FAO: Mark Niland
South Holland District Council
Planning & Development
Council Offices Priory Road
Spalding
Lincolnshire
PE11 2XE

Our ref: AN/2024/135649/02-L01
Your ref: H18-0463-24
Date: 11 September 2024

Change of use from hotel Class C1 to residential Class C3 including the creating of 15 residential units
Bridge Hotel, 4 Bridge Road, Sutton Bridge, Spalding, PE12 9UA

GROUND FLOOR PLAN @ 1:100

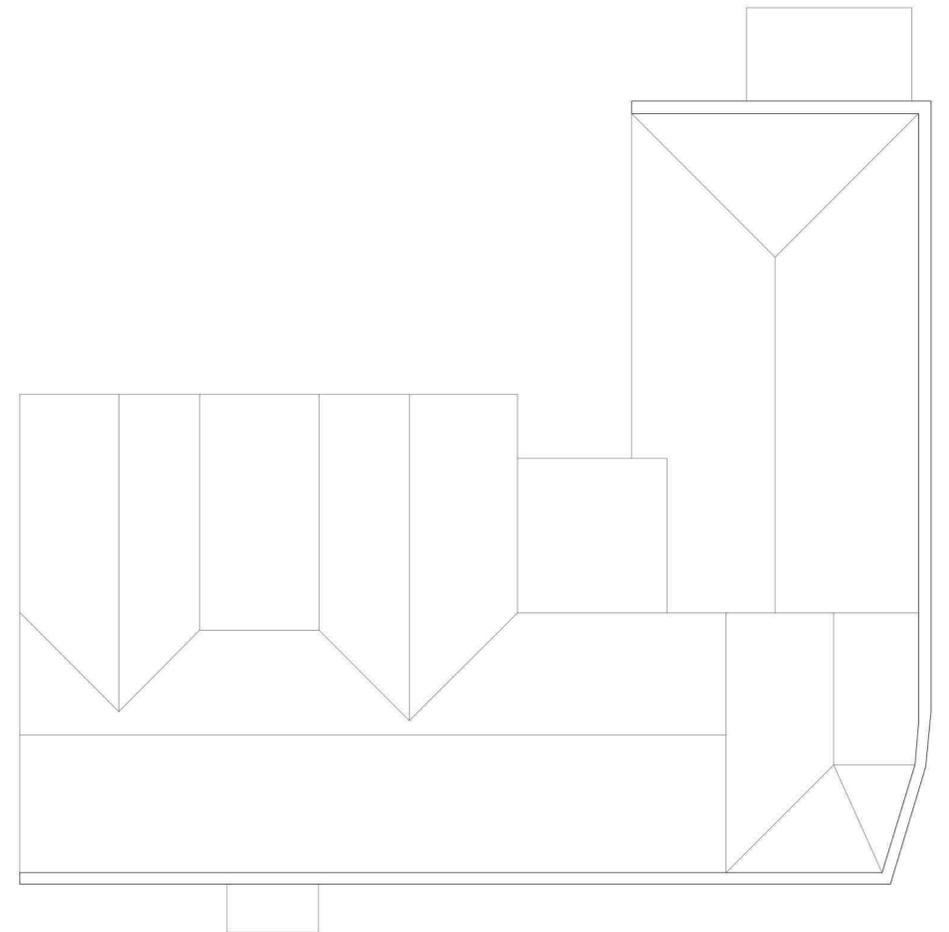
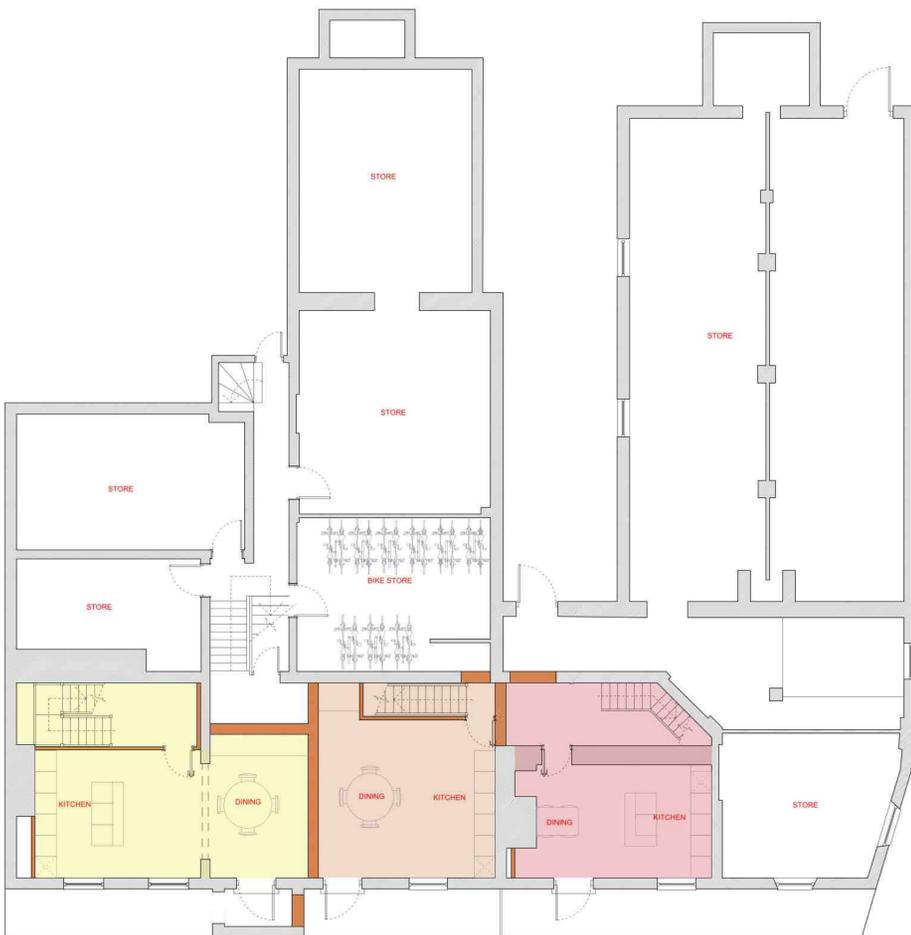
We support the recommendation in the submitted FRA that the lower ground floor/basement level shall not contain any habitable accommodation and shall therefore be used for non-habitable uses only, such as storage. However, the amended floor plans drawing dated 30 July 2024, ref: '723-04-D', prepared by Clayton Architecture Ltd, proposes kitchen/dining uses on the lower ground floor/basement level. We are therefore of the view that the provision for habitable accommodation on the lower

ground floor/basement level poses an unacceptable risk to life, due to the potential inundation of flood water in the event of a breach in the flood defences.

To overcome our objection, the applicant should submit a revised FRA which address the points highlighted above.

In accordance with Policy 4 of the South East Lincolnshire Local Plan 2011-2036, we would not support the provision of self-contained ground floor accommodation, with FFLs below the predicted flood depth, due to the flood hazard posed to people. Should an FFL of 7.25mAOD for the eastern part of the building be unachievable, we advise that the maximum achievable FFL is proposed. In line with Policy 4, we would expect mitigation to be proposed to ensure the development remains safe for its lifetime. We would require unrestricted access to a habitable room above the flood level and an emergency evacuation plan to be submitted, for the approval of the Local Authority.
